From: Alison Pope
Sent: 19 January 2021 15:26
To: DC Admin Planning
Subject: FW: Planning 20/01753/out

With reference to application [20/01753/out](#).

We note this is an application for a separate vehicular access to the outline approved building plot on land adjacent to 46 Harwich road. We wish to object to this for the following reasons.

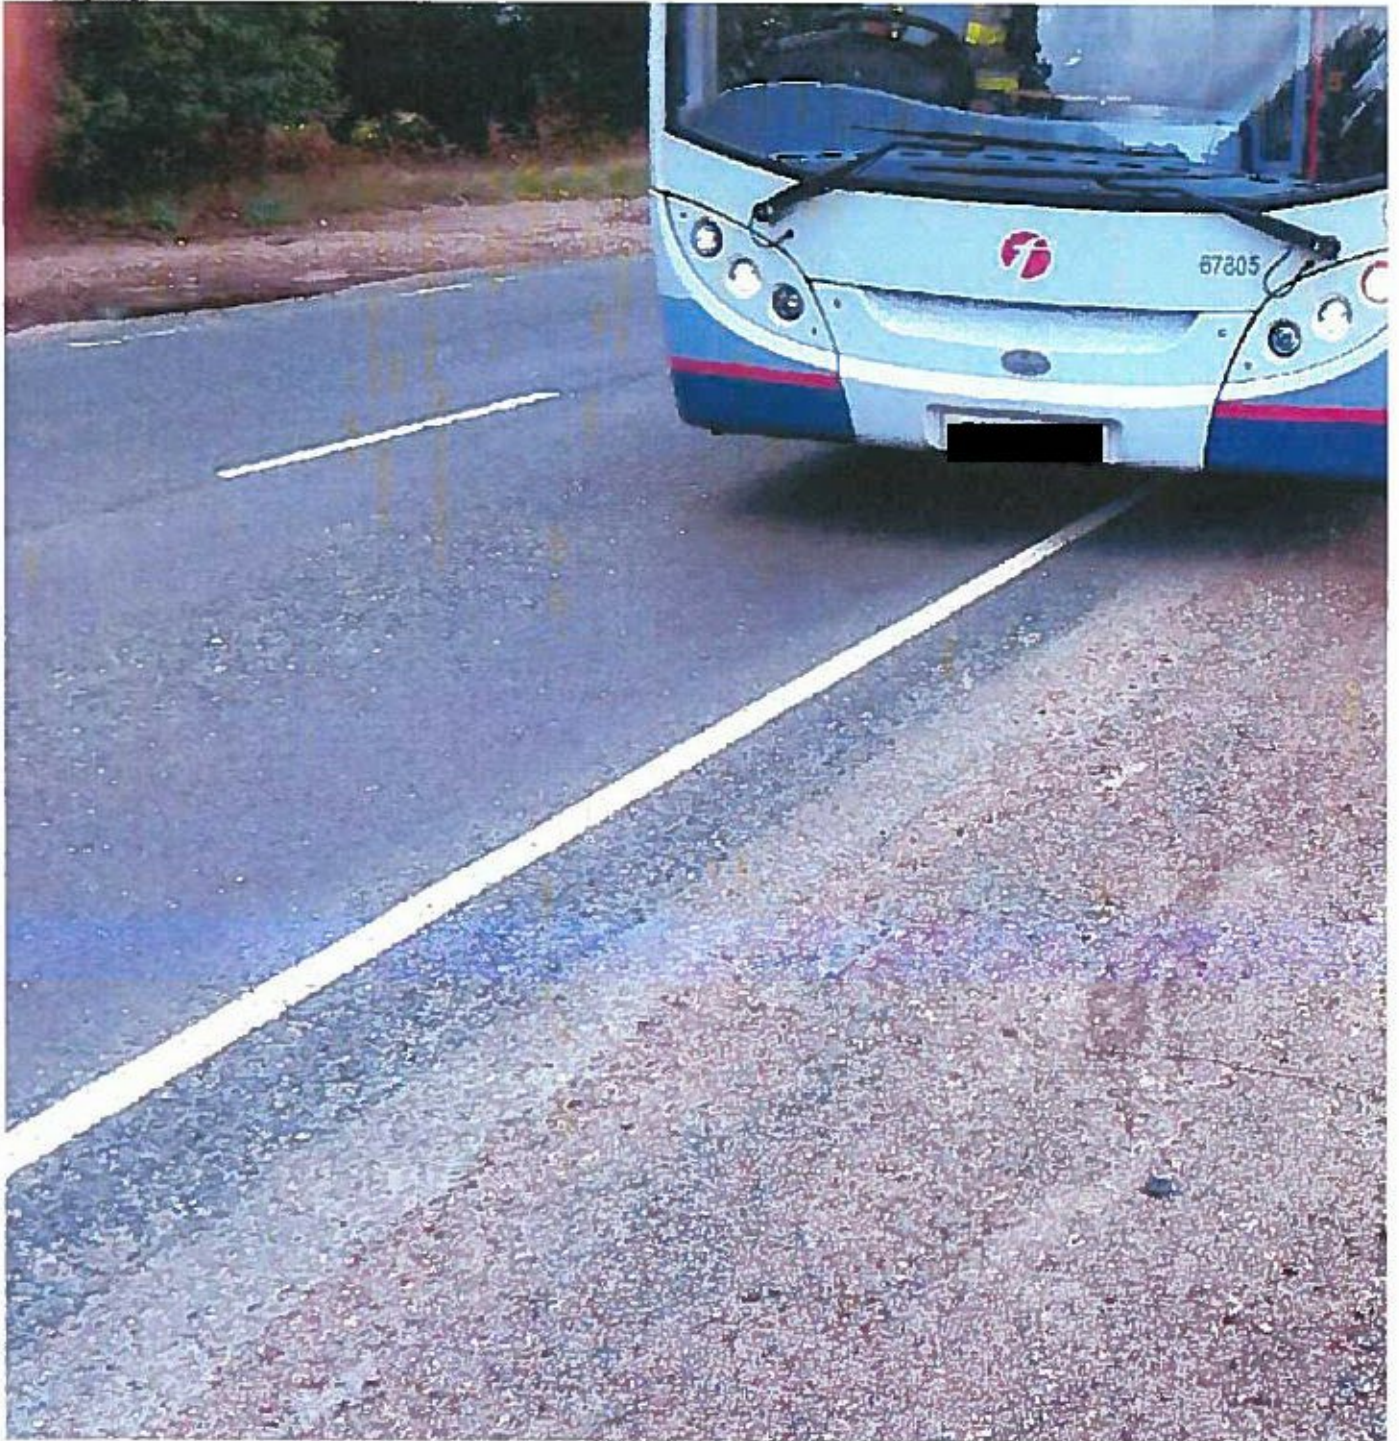
2. As mentioned in this letter there is a tarmac lay-by in front of the property which is used daily as a request stop and by other vehicles as a pull in to seek directions etc. This is a very busy road with ever growing heavier traffic and these lay-bys are of increasing importance.

As can be seen by the photographs recently put up by the application that the lay-by is constantly used. And clearly show the second cable vault.
